**SSD-69257218 at 60 GREAT SOUTHERN ROAD BARGO 2574**

I refer to the Department's email of 11 March 2025 regarding the Environmental Impact Statement (EIS) for State Significant Development SSD-69257218 Mixed-use development with in-fill affordable housing, 25 Moss Vale Road Bomaderry for 'Mixed use development with 196 dwellings, including attached dwellings, six residential flat buildings and shop top housing, commercial tenancies, a boarding house, a childcare centre, a medical centre, at grade parking and public domain works' at 25 Moss Vale Road Bomaderry (Lot 110 DP 131219, Lot 129 DP 3060, Lot 1 DP 520502) in the Shoalhaven City Council local government area (LGA). Submissions need to be made to the Department by 7 April 2025.

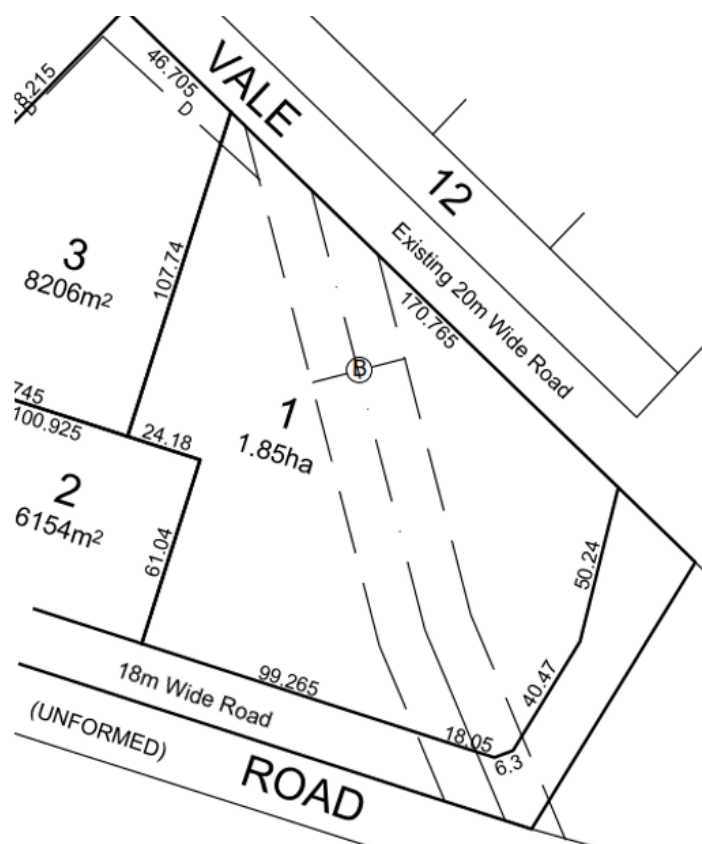
The EIS mentions but does not appear to address in detail the easement for 33,000 volt / 33 kilovolt (kV) overhead transmission lines. The Master Plan shows the proposed subdivision of part of the easement which is opposed by Endeavour Energy ie. as per SF10851 the easement should be entirely within proposed Lot 1 – but which appears may be rectified by the 'Building Setback for Possible Future Road Widening'. There does not appear to be any evidence of any consultation / approval from Endeavour Energy's Easements Officers.
